MOUNTAIN'S EDGE FILING 1

PCD File No. SF201

FINAL PLAT
MOUNTAIN'S EDGE FILING 1

FINAL PLAT  
MOUNTAIN'S EDGE

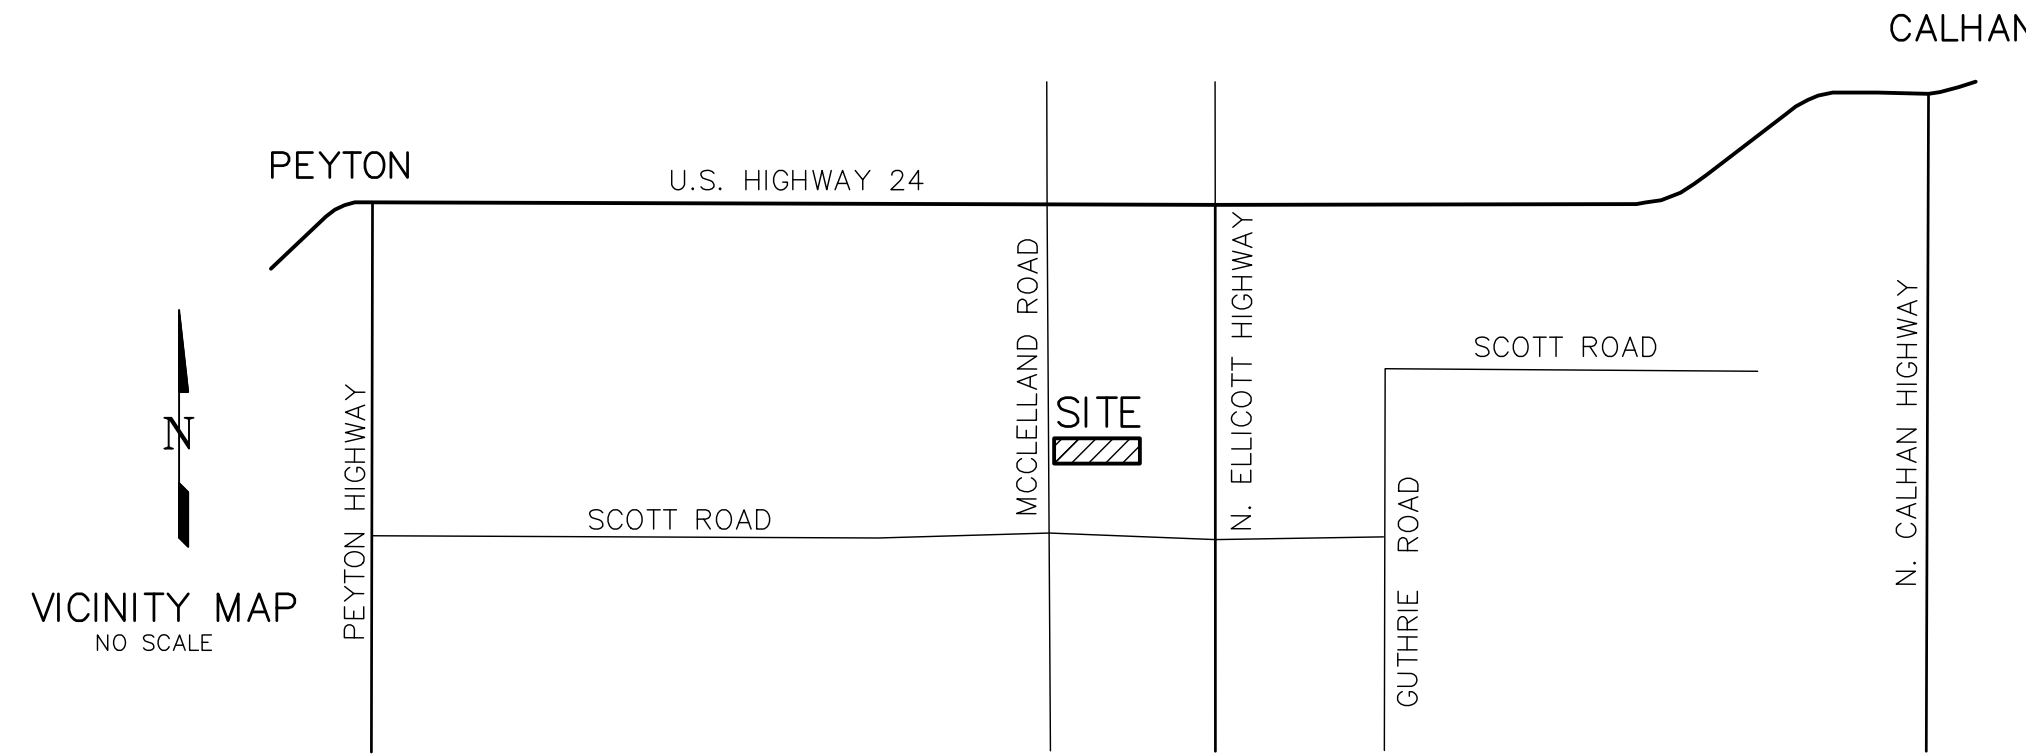
Previous comment not addressed: Identify which lots need engineered foundations and septic systems, per soils & geology report.

Previous comment unaddressed: Update this information to reflect new report. Revise Development Services Department to Planning and Community Development Department.

Previous comment not addressed: Explain purpose of no-build.

This is already included within Note 6. Incorporate this additional information into that note.
